Our Ref: EN010120

Date: 20 June 2022

Application by Drax Power Limited for an Order Granting Development Consent for the Drax Bioenergy with Carbon Capture and Storage Project

Advice following issue of decision to accept the application for examination

EN010120-PA-EN-2.5-Sheet1

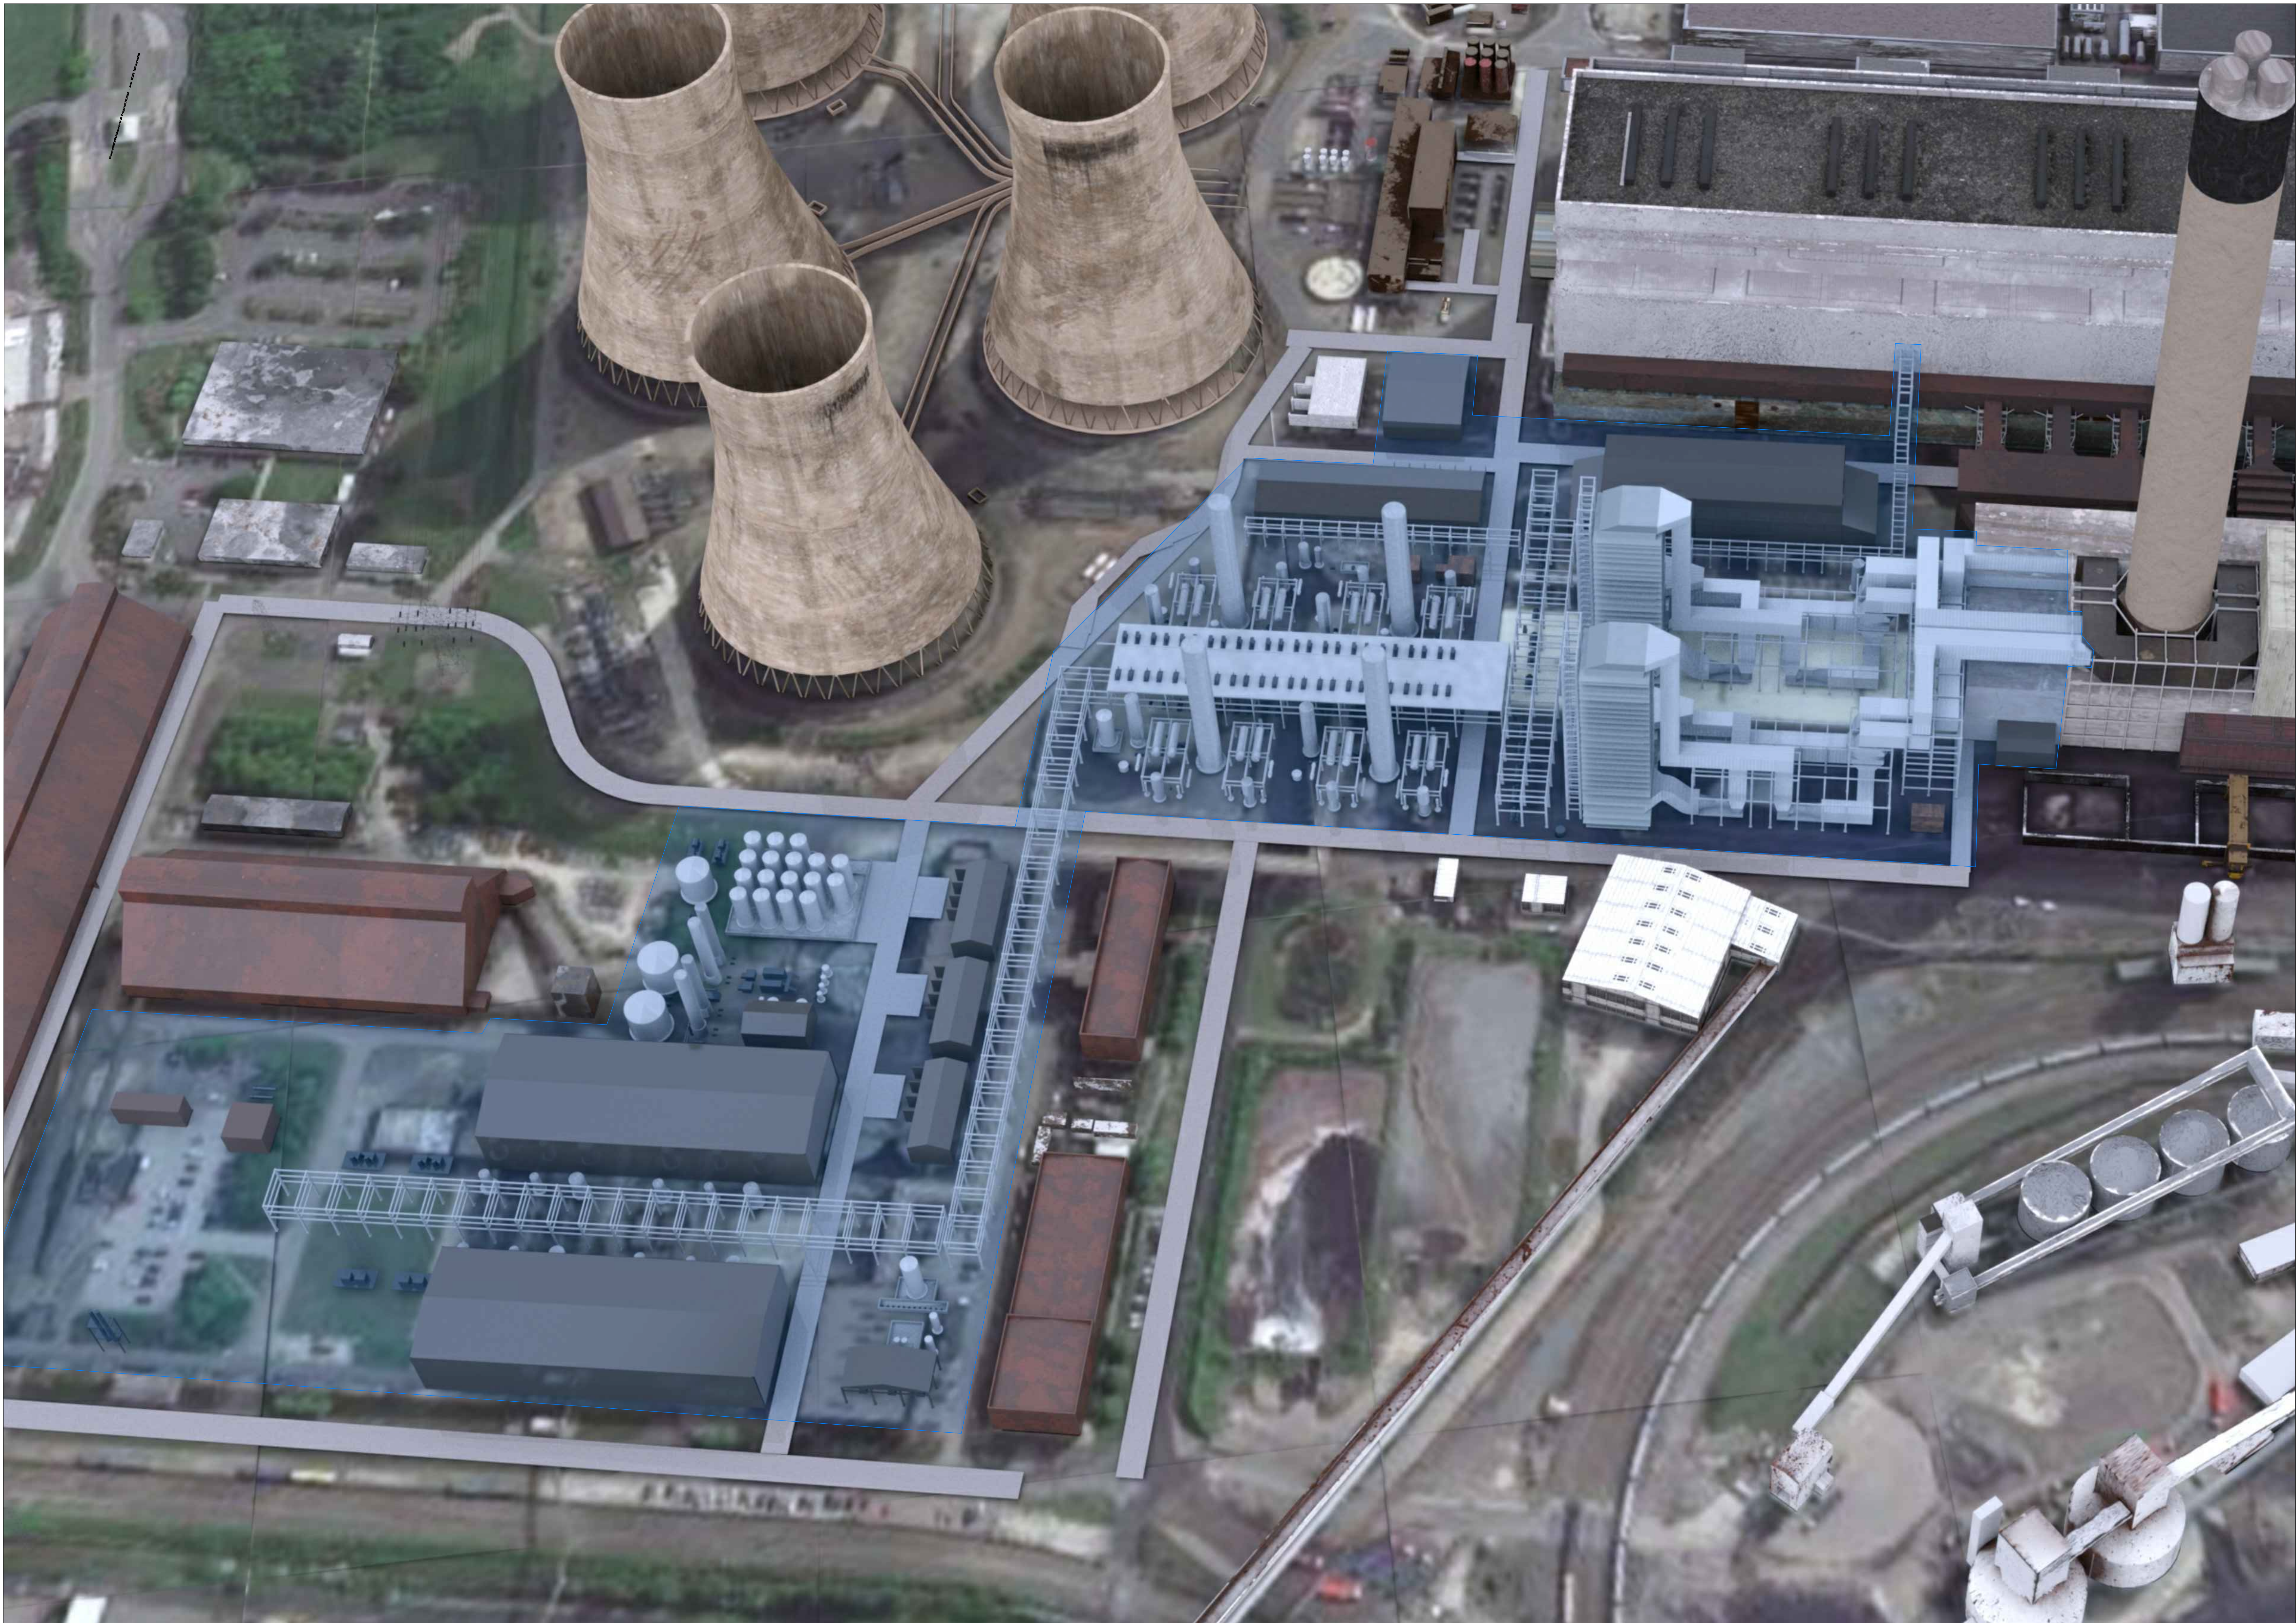
The Planning Inspectorate notes that the plans within the Indicative Plans and Elevations do not show the direction of North, and therefore the Applicant is requested to resubmit this document ensuring that the direction of North is shown on each plan sheet.
